CITY OF ALBUQUERQUE

January 24, 2017

**Re: Drainage Control Ordinance (14-5-2-1) and NPDES CGP Violations for
Cement Pollution and Erosion and Sediment Control- Fairfield Suites**

### Silt Fence

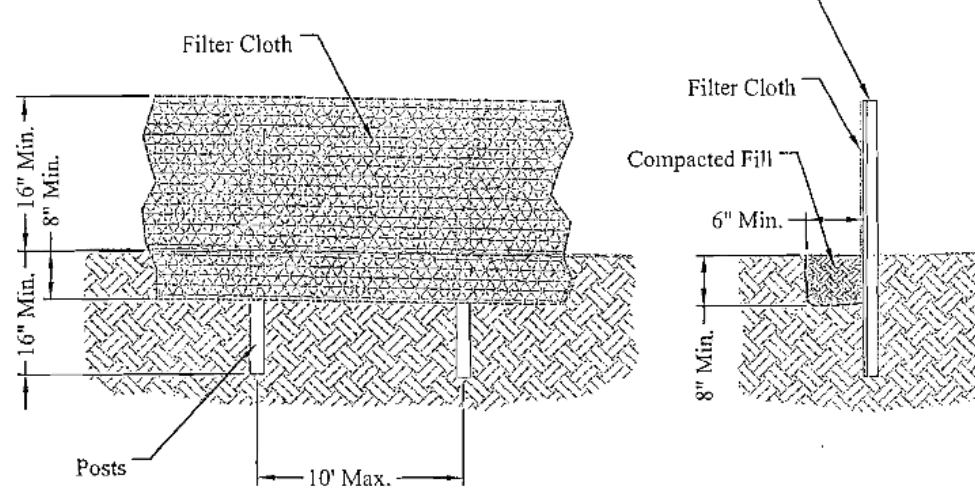
In addition, the sediment BMP (silt fence) had a gap along the southern boundary and sediment has entered the site to the south.

1. Remove the cement pollution and provide an acceptable concrete/mortar/stucco wash-out receptacle.
2. Provide a sediment BMP(s) to prevent sediment from migrating offsite.

The violations are to be mitigated within 30 days or the property owner is subject to a fine of \$500/day per the City's Drainage Control Ordinance.

Fairfield Suites

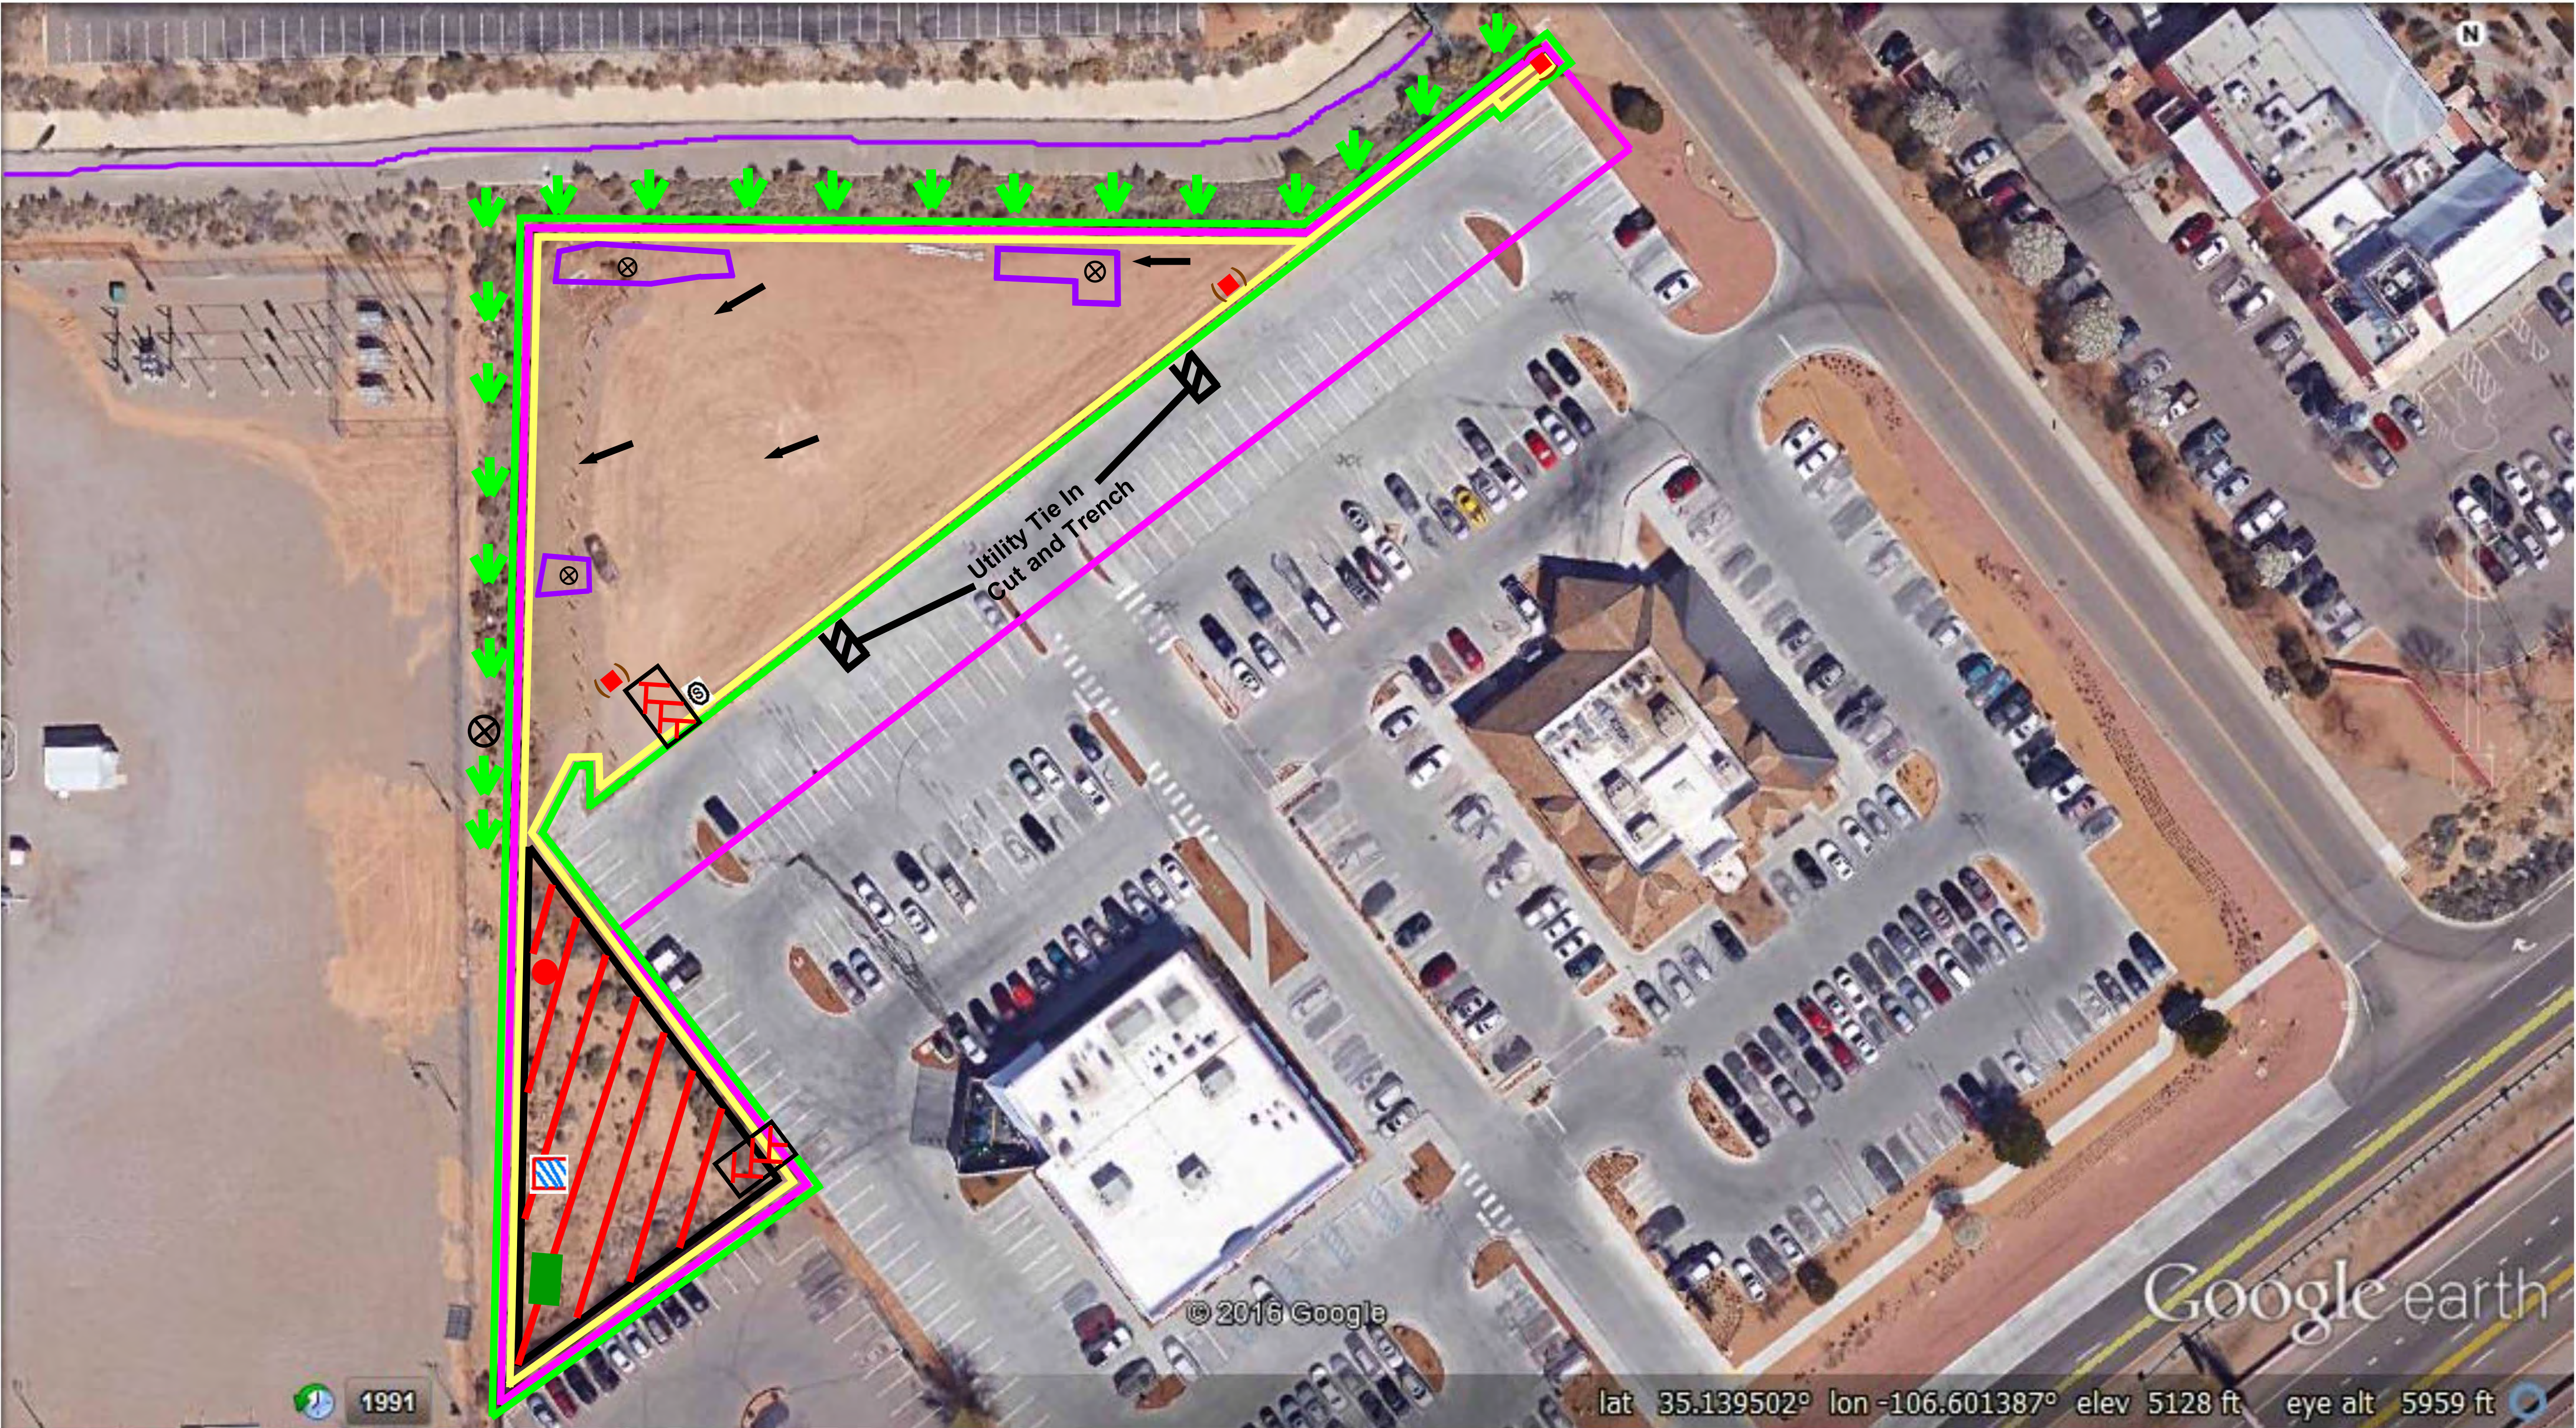
1. Numerous instances of cement pollution were observed on the site and an acceptable concrete/mortar/stucco receptacle was not on-site.
